Environmental Health Consultation Response

To	Mr S Davis
Date	17-08-2026
Planning Ref	F/36/26/OUT
Site Description	Paynters Croft Burndell Road Yapton Arundel West Sussex BN18 0HR
Date of Application	2026-07-08 00:00:00
Category	Outline Planning Permission
Recommendation	No Objection No Objection – with conditions Objection Holding Objection

NM02: Burndell Road - 28 Jun 2024

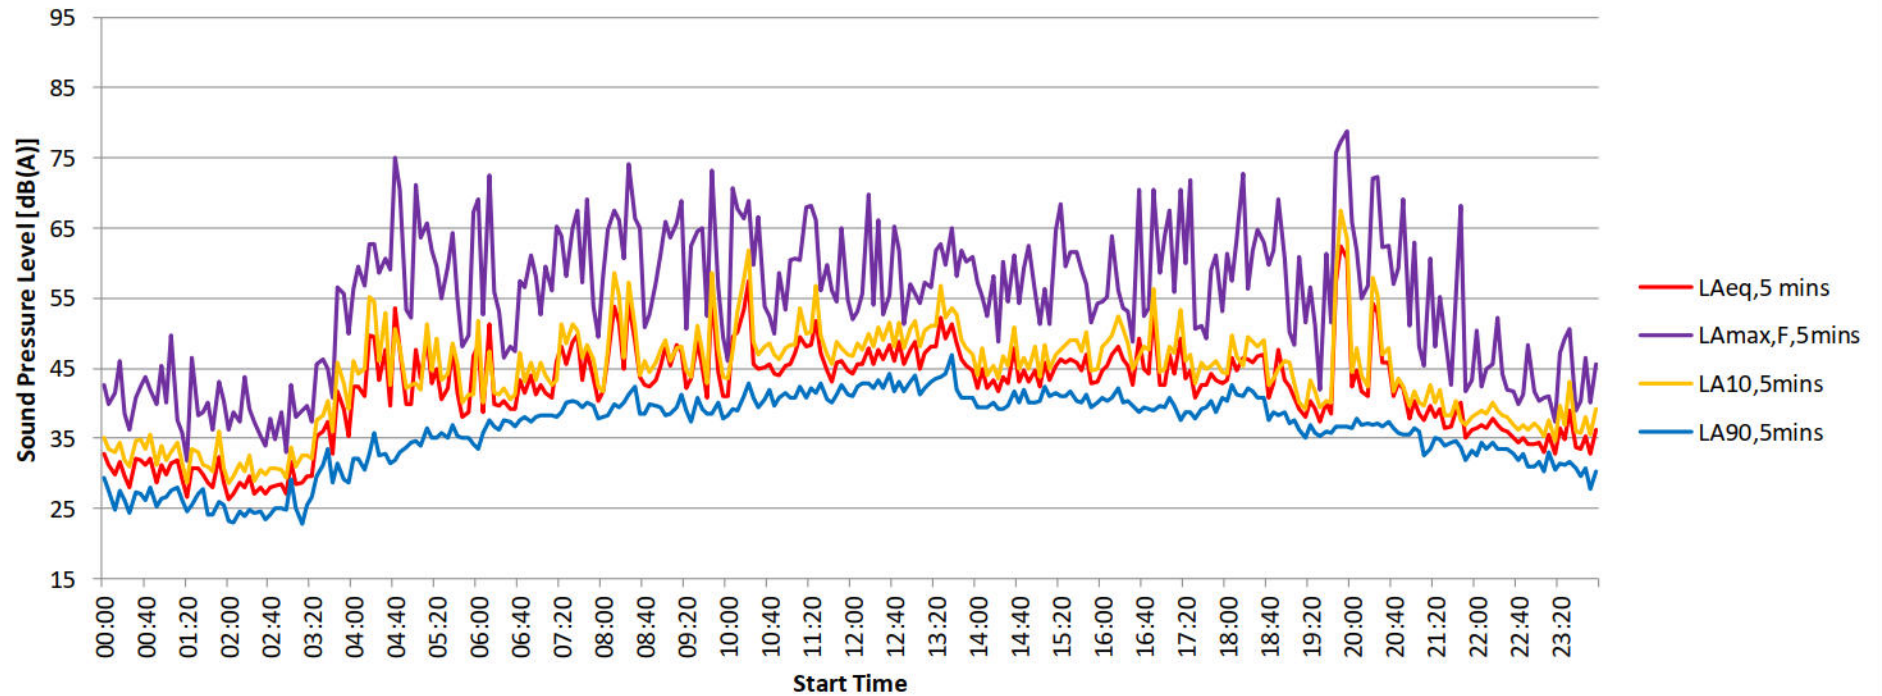
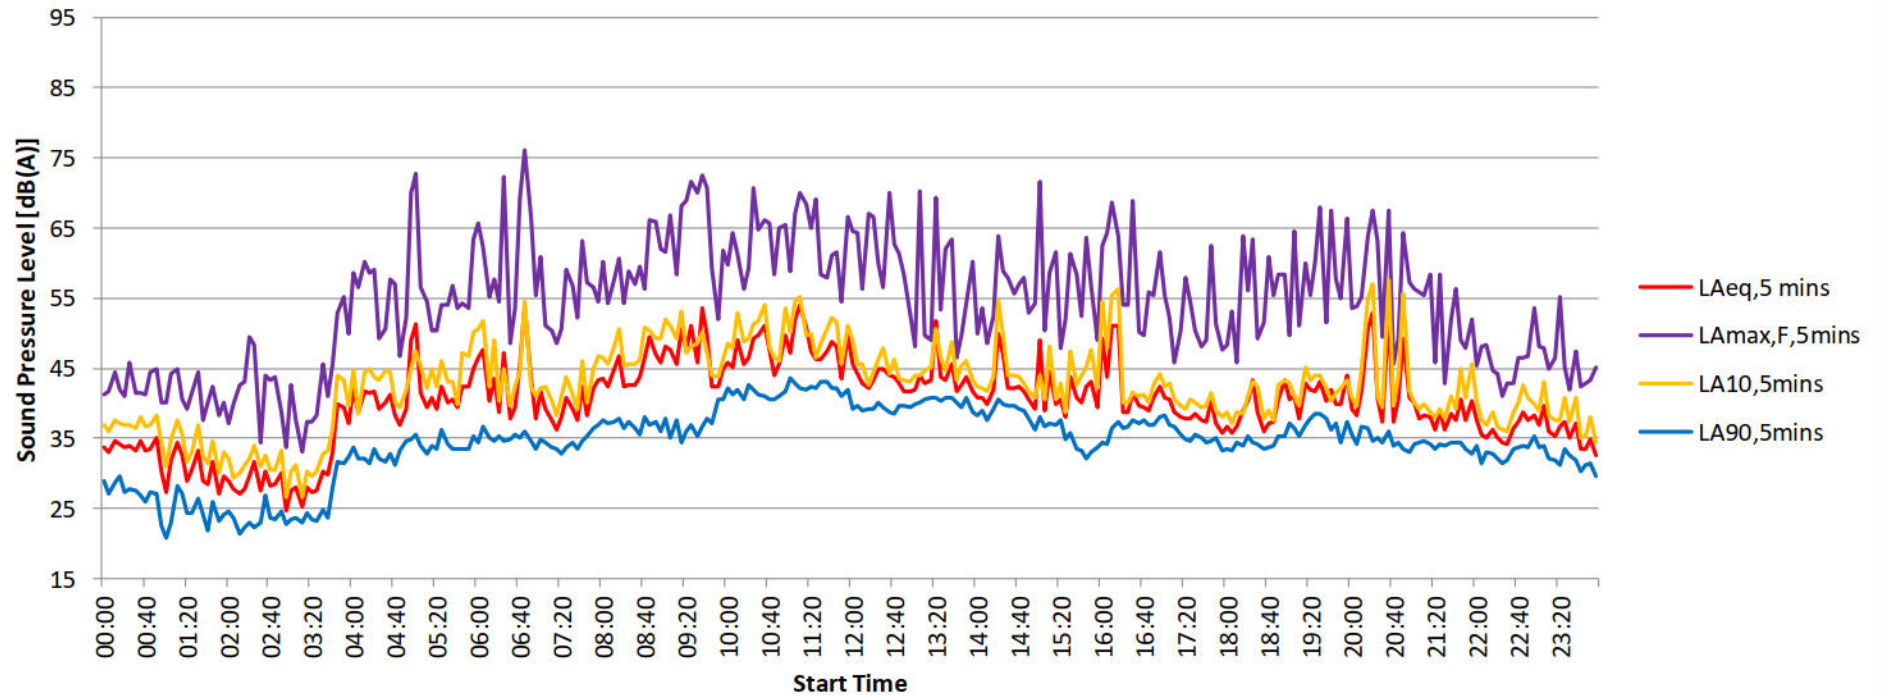
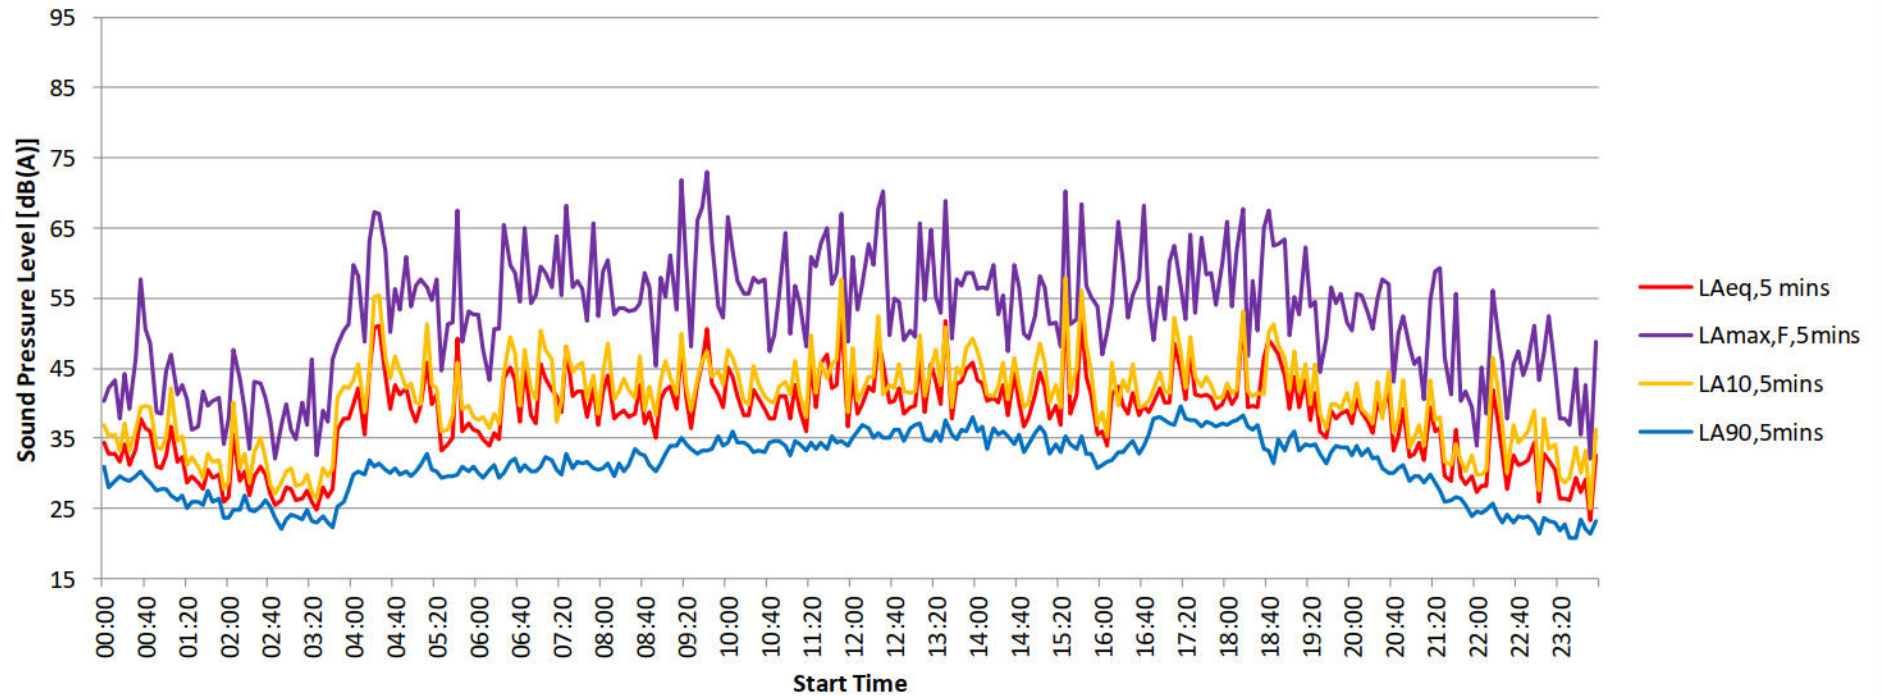
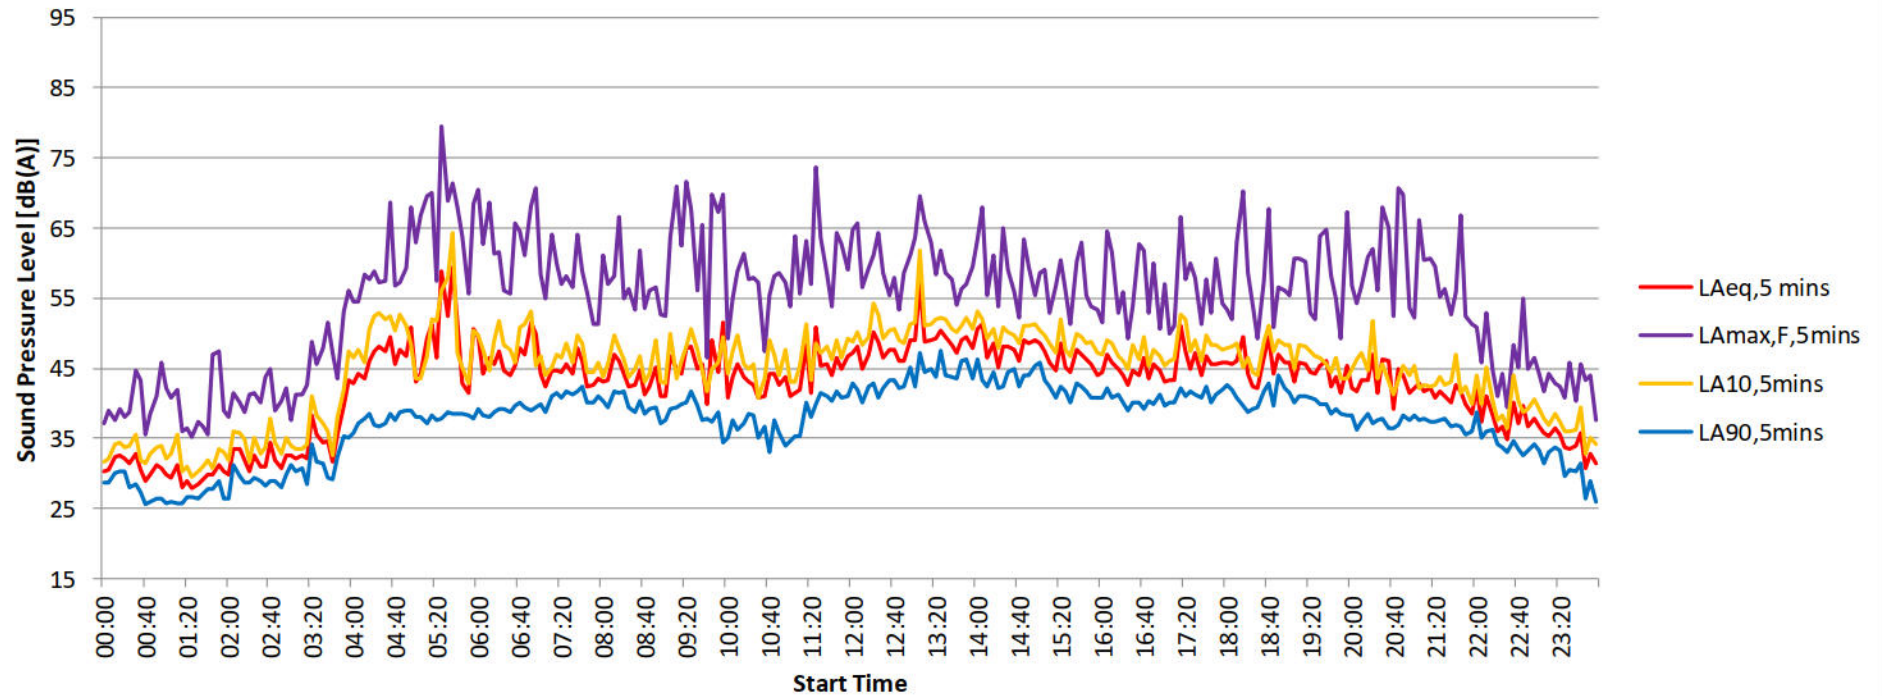
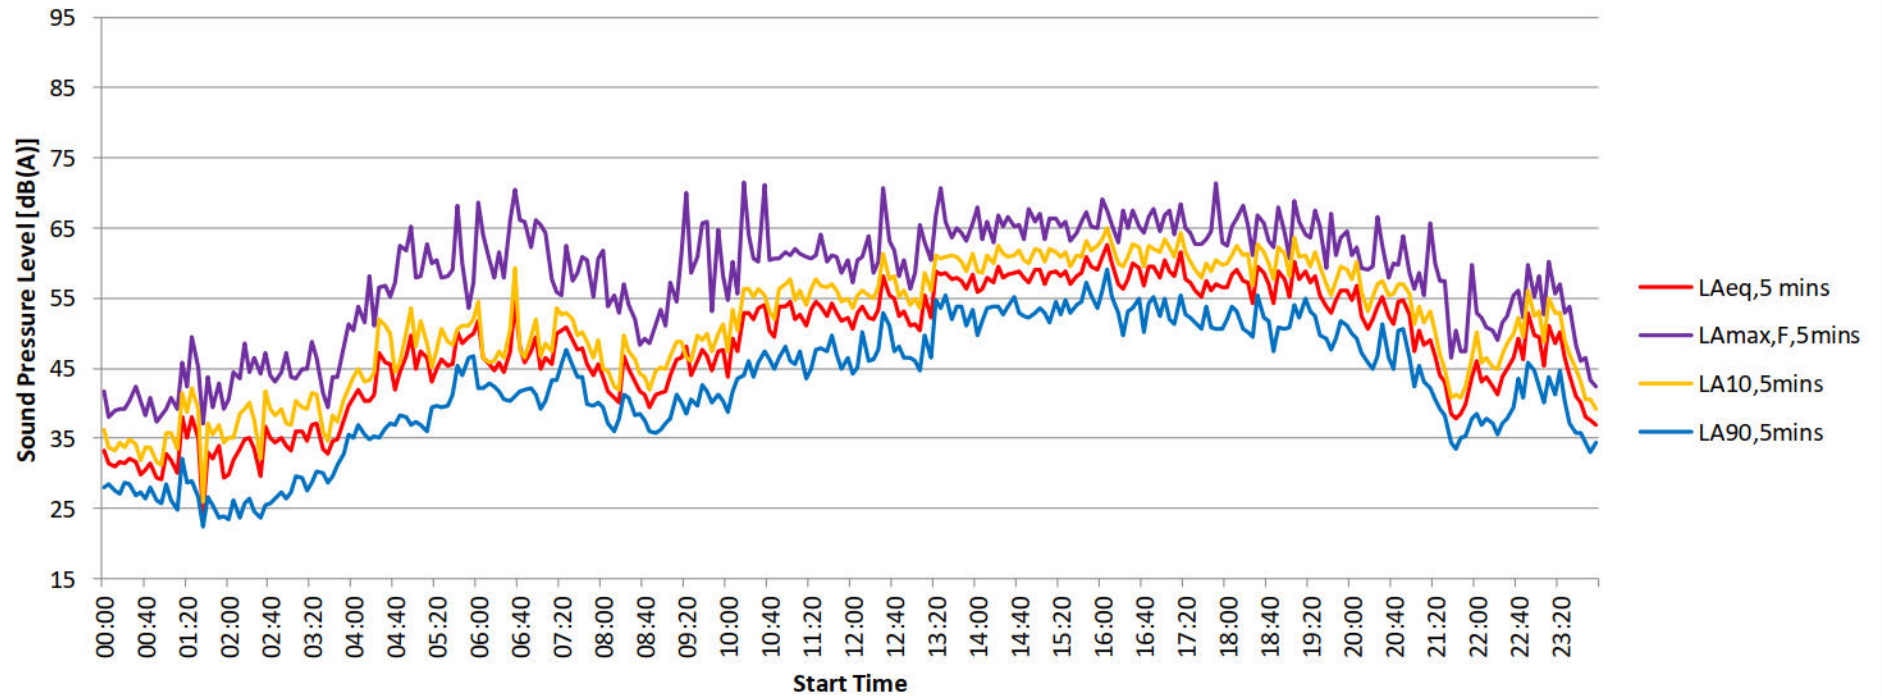
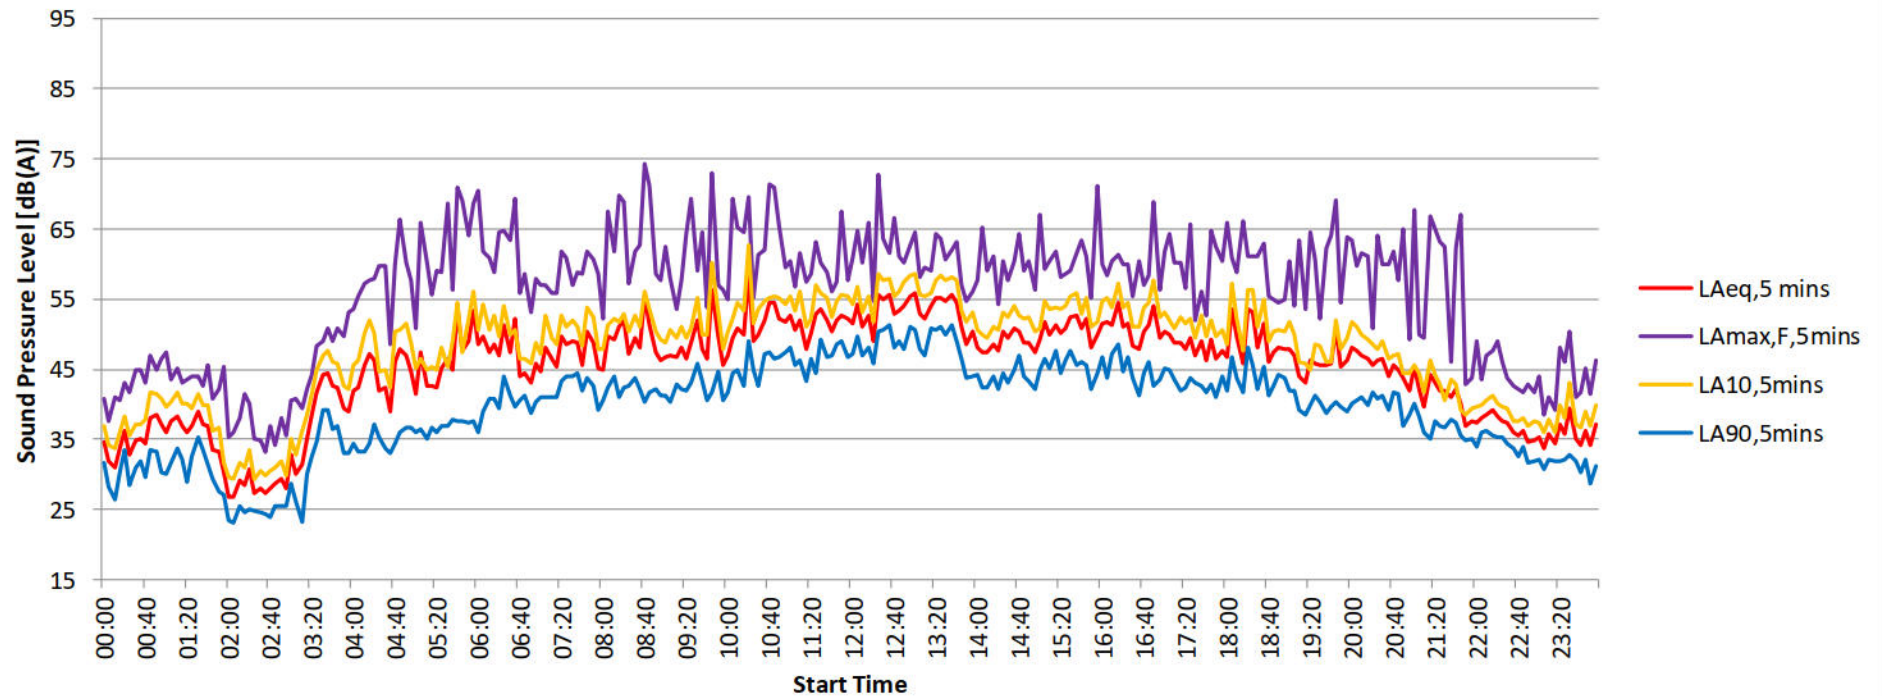
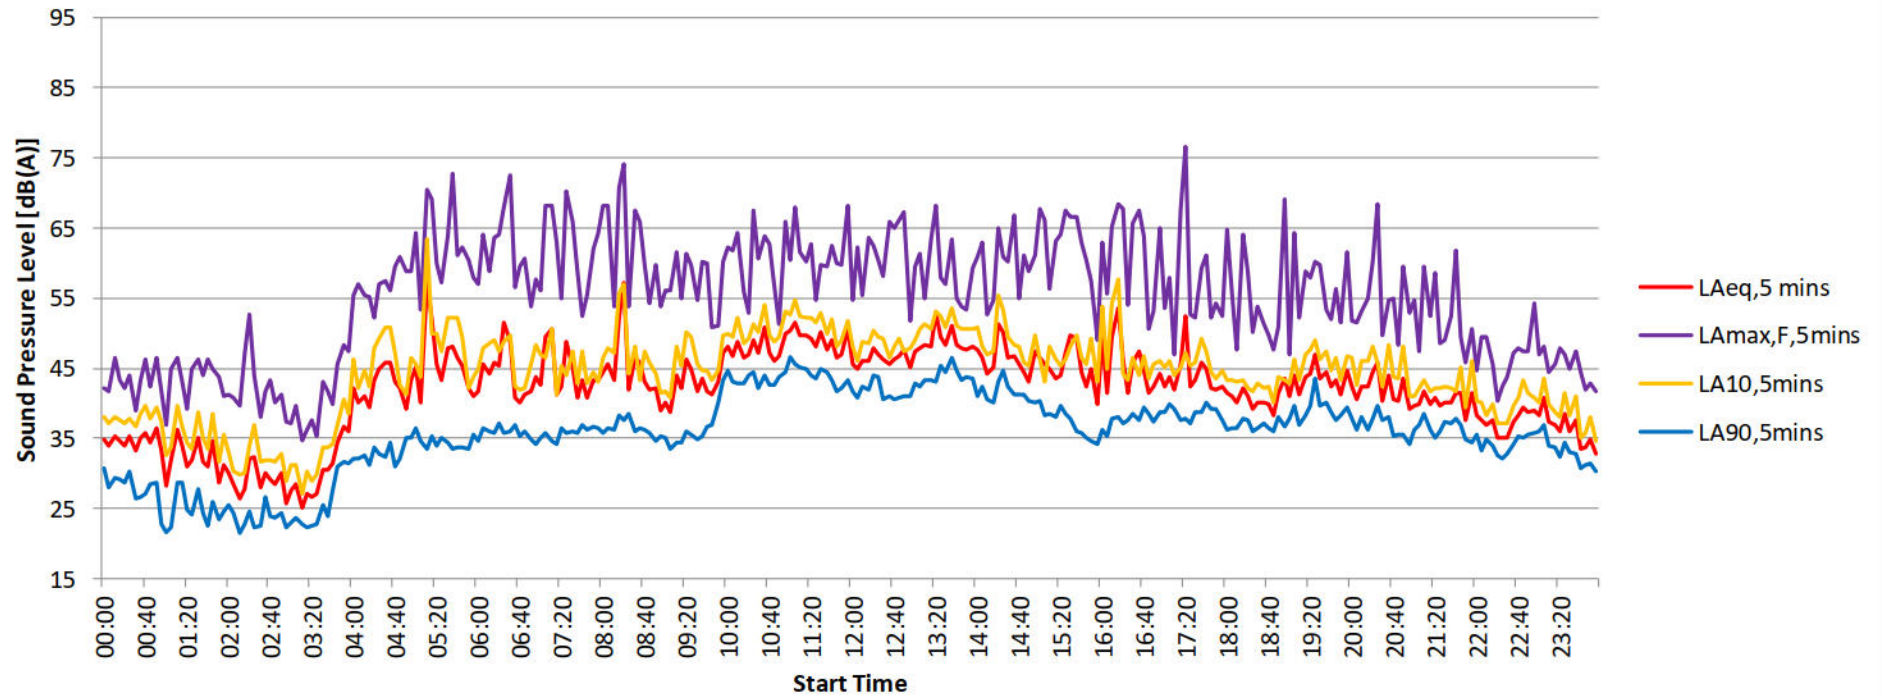
A noise assessment has been submitted, prepared by Phlorum, reference 13174, dated May 2026. The report is generally sound in approach; however, the noise survey work on which it relies was undertaken in 2024. Since that time, I understand that the adjoining industrial units have increased their hours of operation, this change may affect the noise climate to which future residents would be exposed.

On this basis, further confirmation is required to demonstrate that the noise levels and internal and external amenity standards set out in the Phlorum report remain representative and achievable having regard to the current and permitted operation of the adjoining industrial and waste uses.
